**Notification of Modification Request – Prestons Warehouse and Distribution Centre
(SSD 7155 MOD 2)**

CD17/08076

Drawing:
SITE PLAN - COLOURED OVERALL ESTATE PLAN
 Drawn: AA Date: November 2015 Scale: 1:1000 @ A1 1:2000 @ A3
 Project No: 140604 Drawing No: S96 - A 102 Issue: L

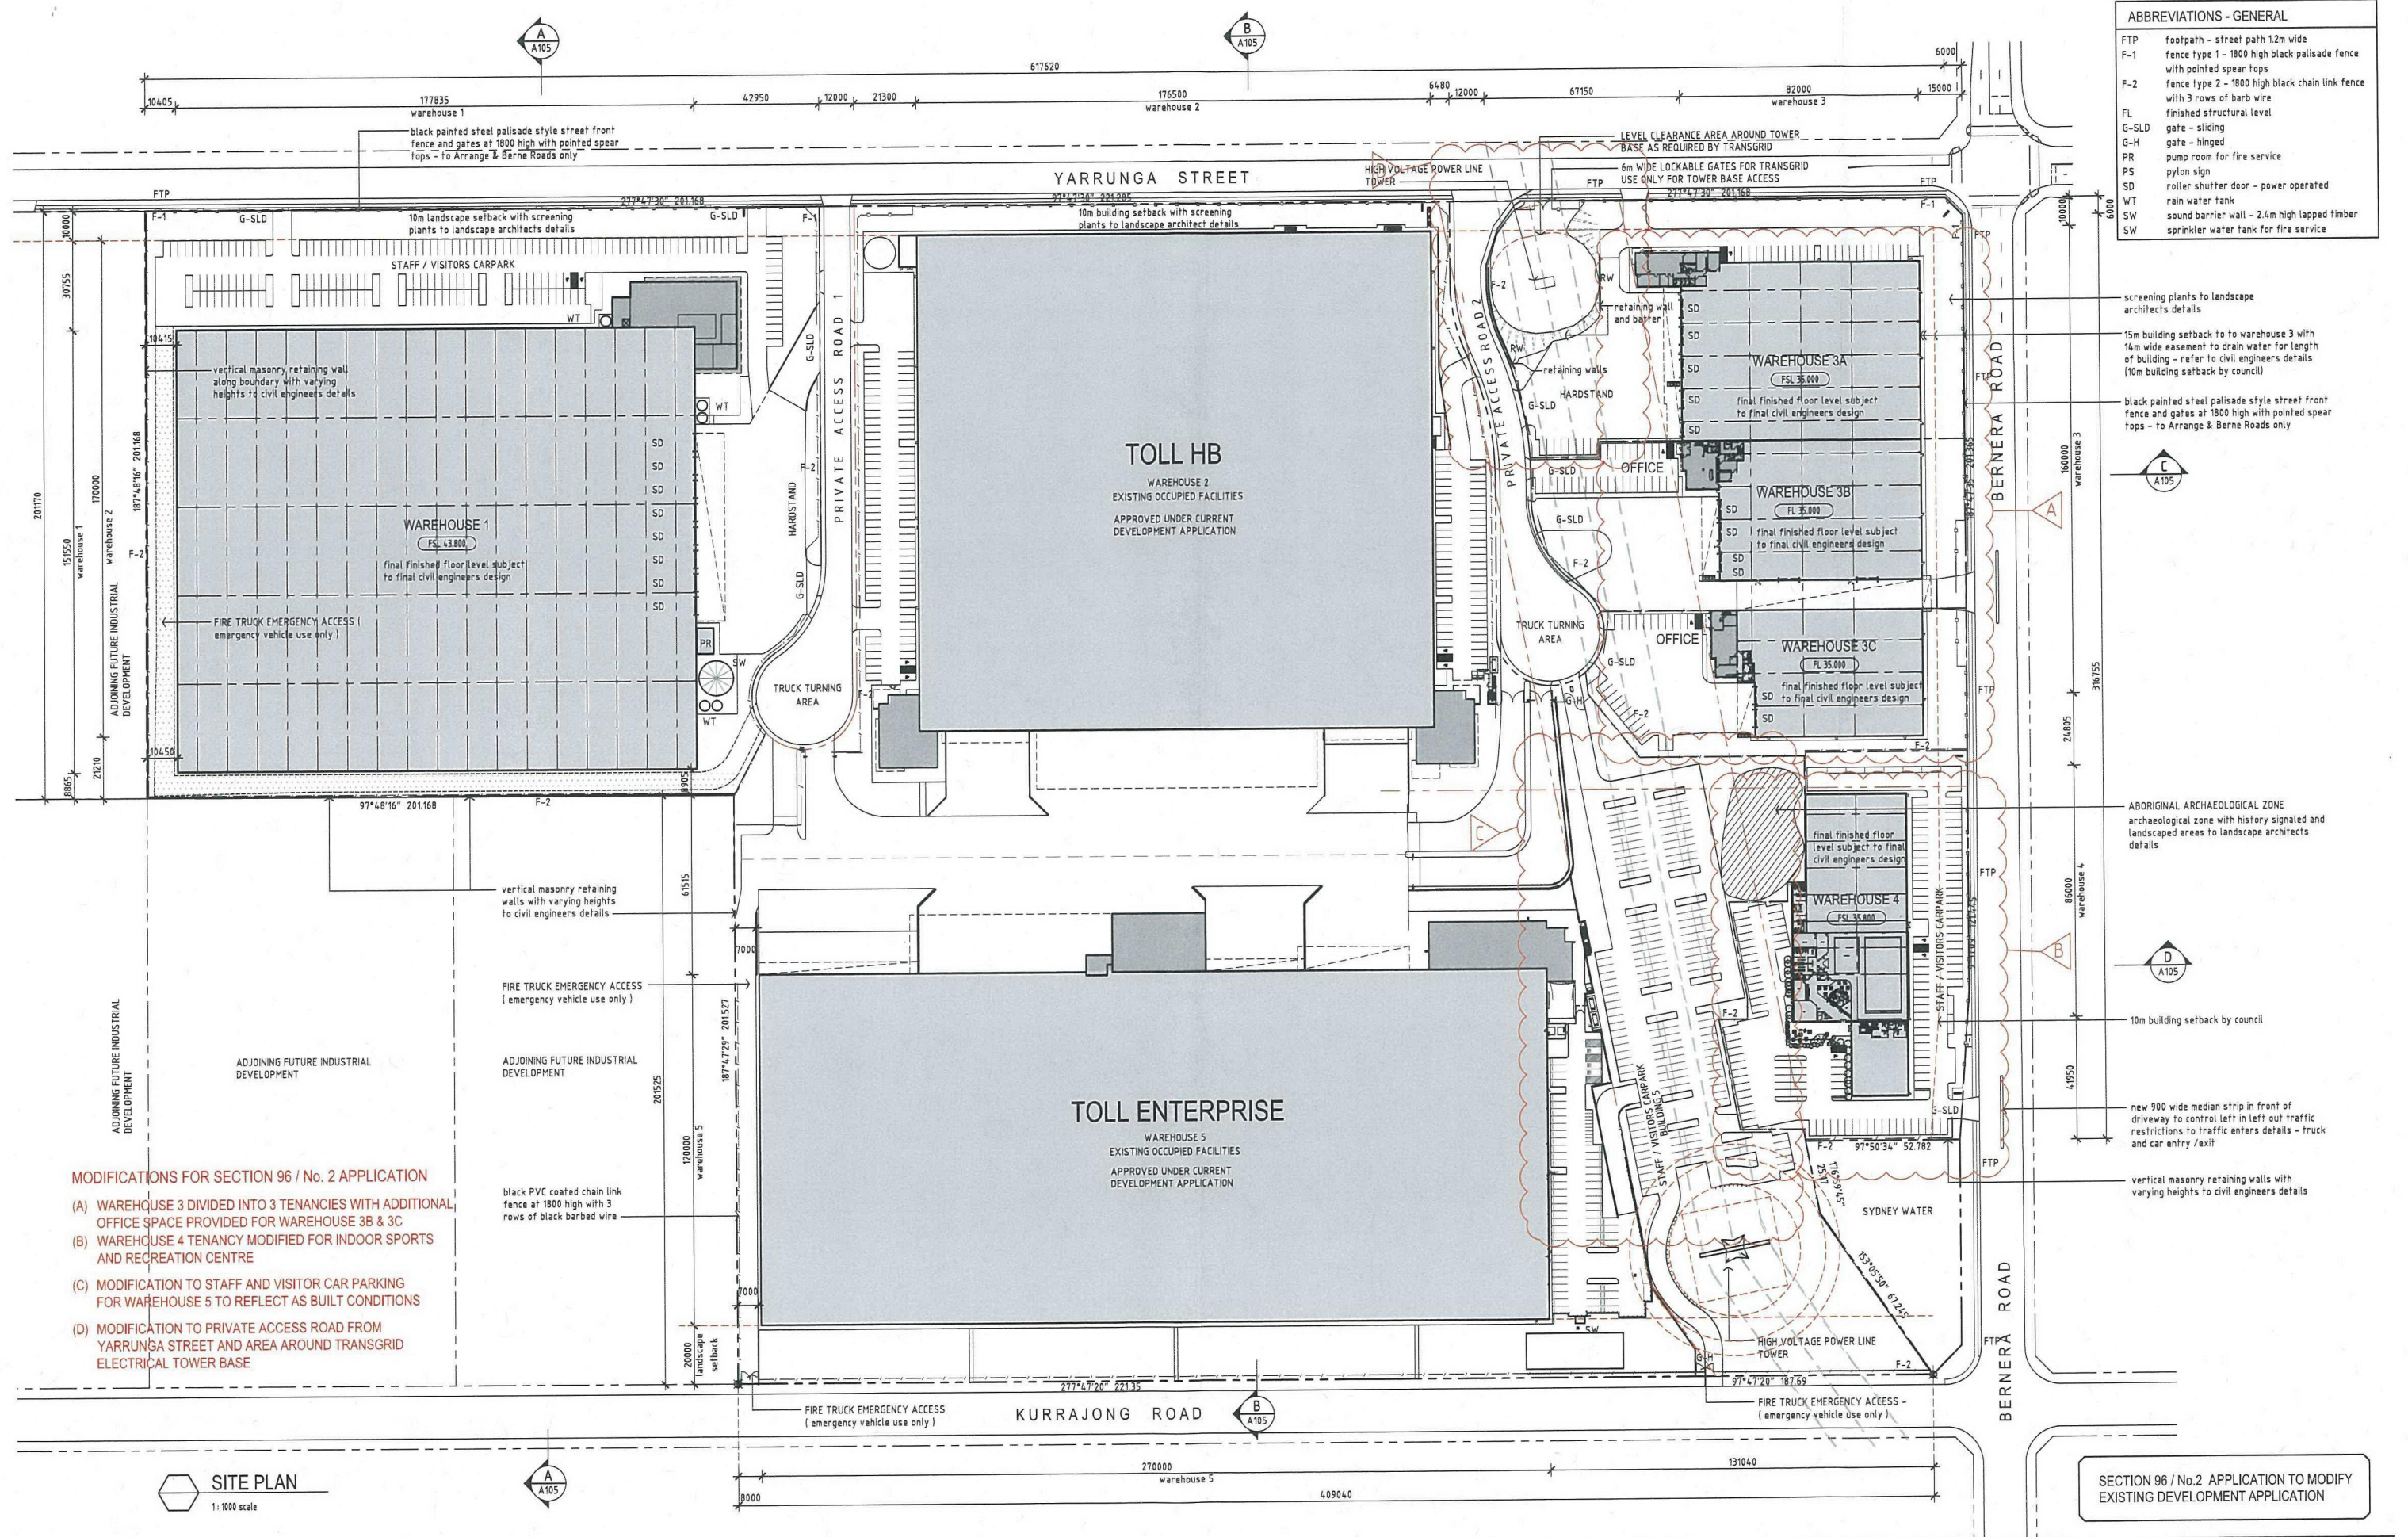
The approved plan indicates the emergency gate for access to Warehouse 3 will only be used if Transgrid blocks the private access road during maintenance to powerline tower.

The proponent should clarify whether such access arrangement remains the same under the proposed modification or otherwise the proposed modification should indicate the change of emergency gate for the three warehouses (3A, 3B and 3B).

PROPOSED MEDIAN/CHEVRON ARRANGEMENT

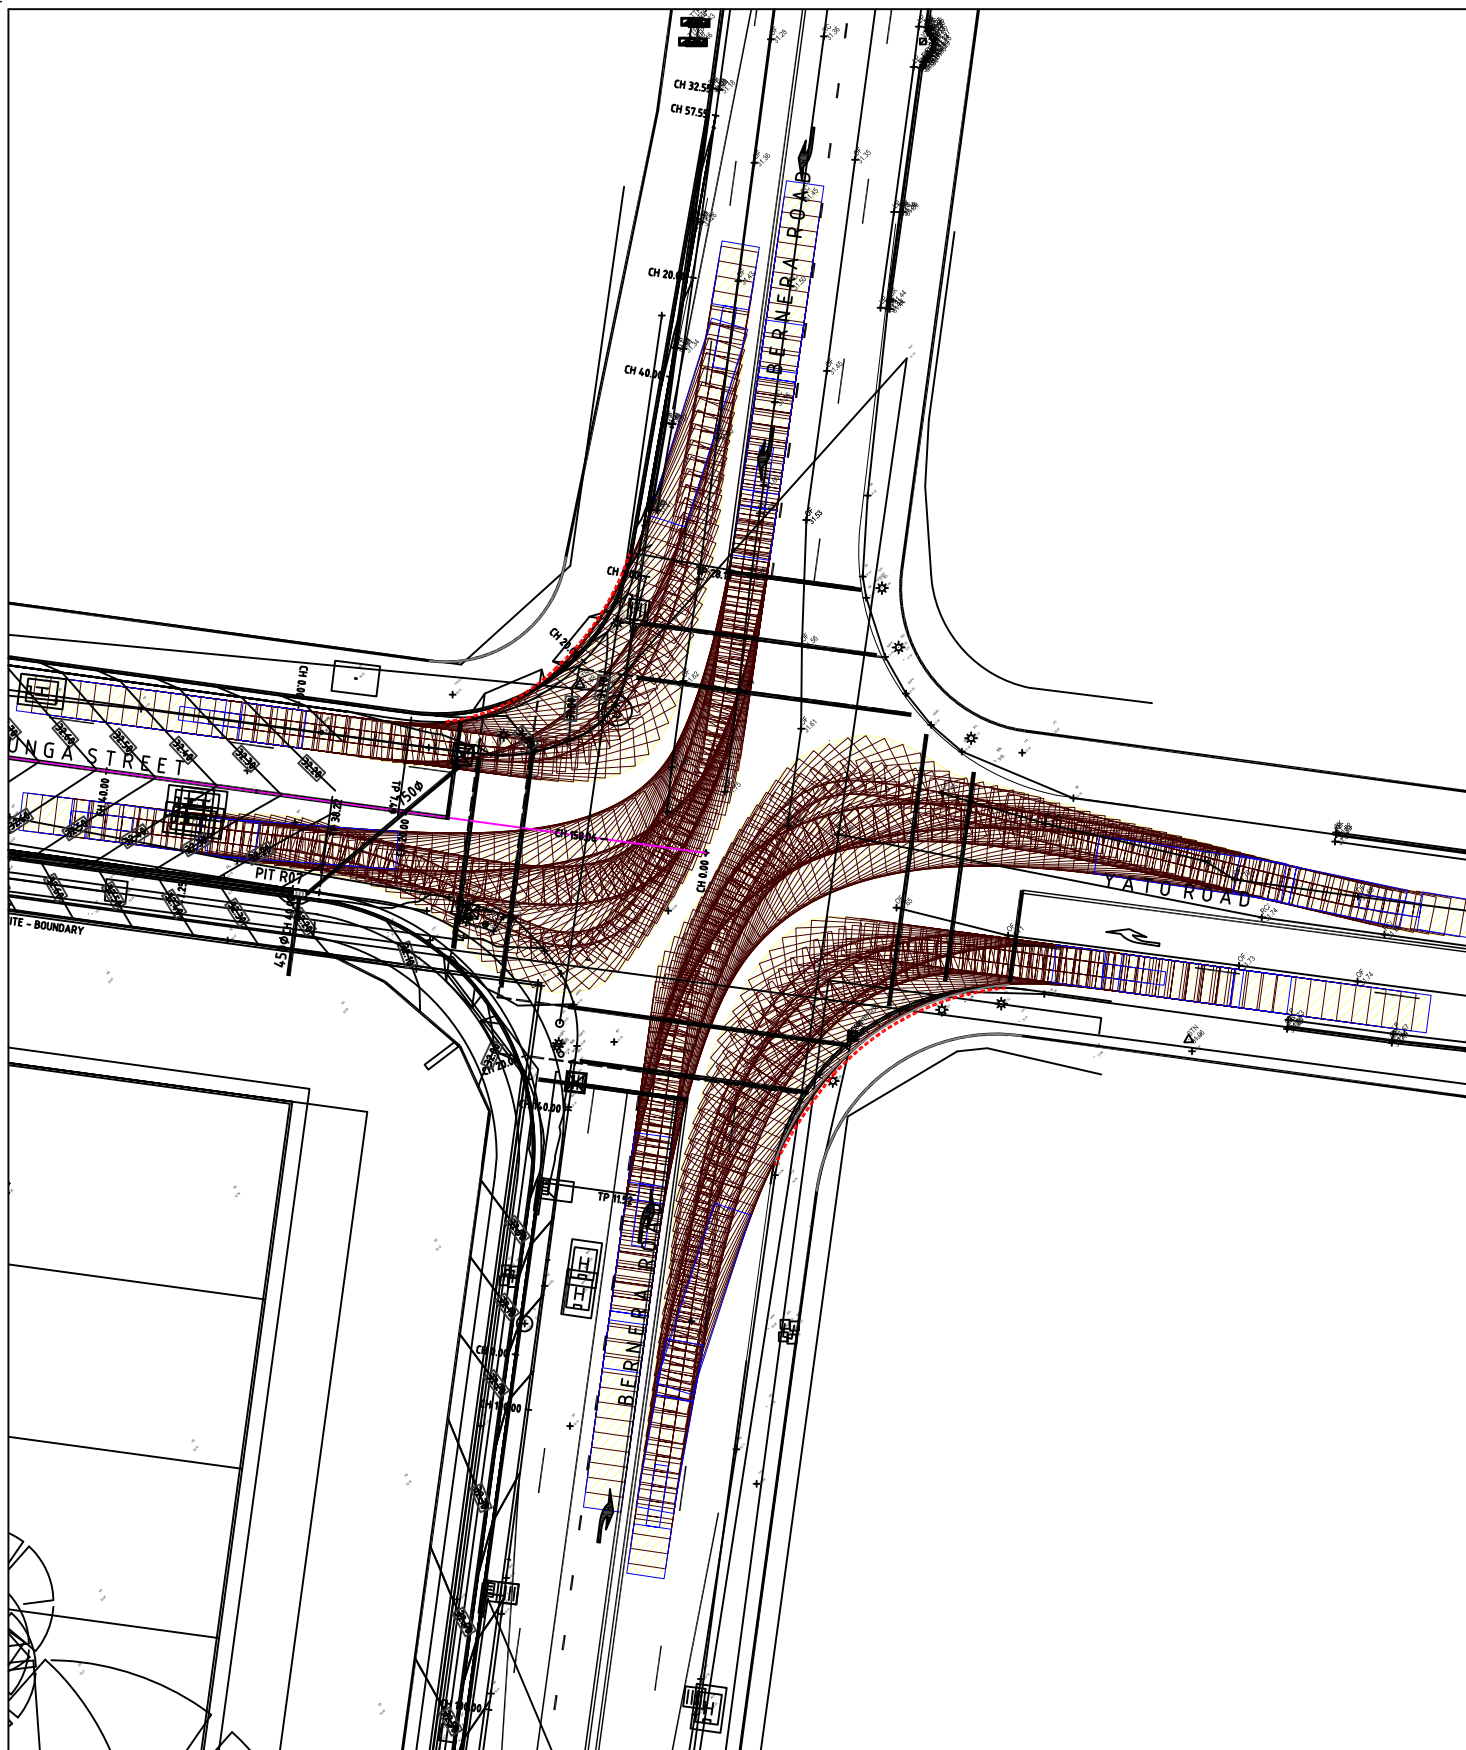
It is noted that the intersection upgrade on Bernera Road and Yarrunga Street is required under the Development Consent for the original application. The current modification had incorporated the proposed layout for this intersection upgrade.

The details of this proposed intersection including but not limited to traffic signal phasing and timing, layout, and etc., should be reviewed and designed to the satisfaction of Council and Roads and Maritime Services.
